From: [Jeremy Larson](#)
To: [Jeremiah Cromie](#)
Subject: RE: SI-23-00001 Manastash Estates - Notice of Application
Date: Tuesday, February 14, 2023 4:53:19 PM
Attachments: [22- SIGNS.pdf](#)

S1-23-00001 Manastash Estates

TO: All Staff
FROM: Public Works Plan Review Team
DATE: February 24, 2023
SUBJECT: SI-23-00001 Manastash Estates

① **Elevation: Pillar Sign**  
 Scale: 3/4

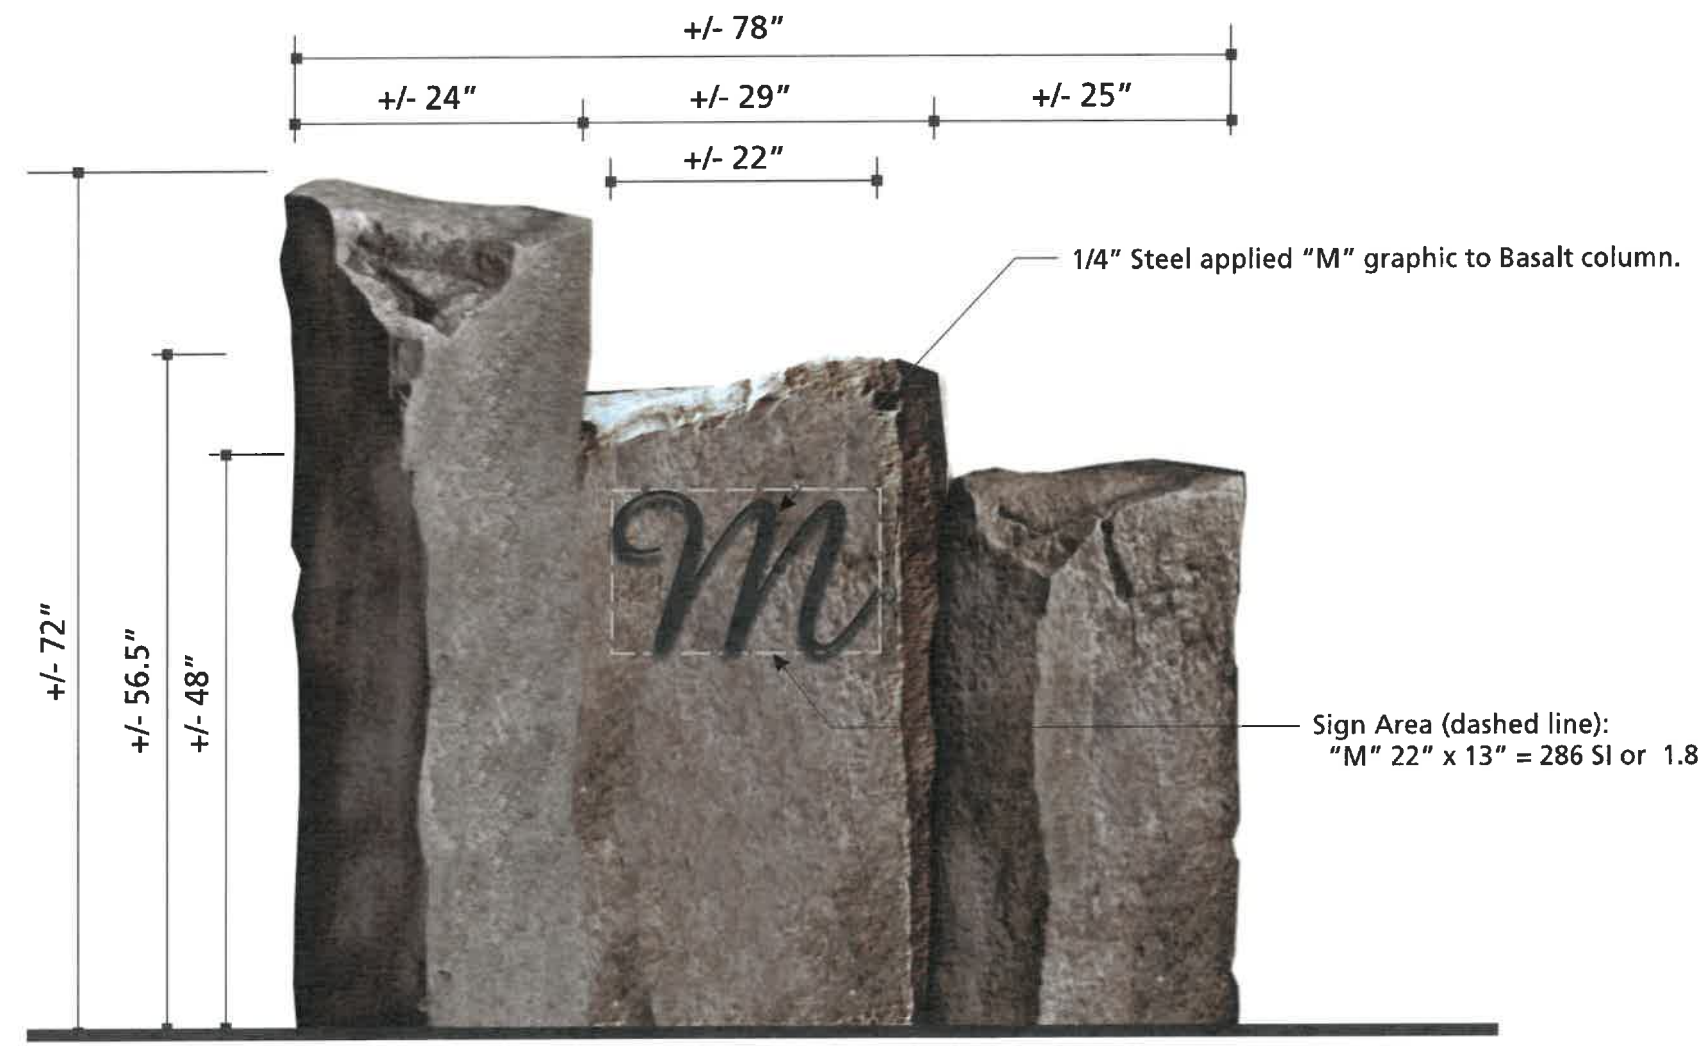
Thank you for your request for comment. Per Kittitas County CDS Sign Permit Policy (Item 22), a building permit is required. Additionally, due to the spacing of the posts being over eight (8) feet, the sign must be fully engineered. The Sign policy is attached to this email for reference.
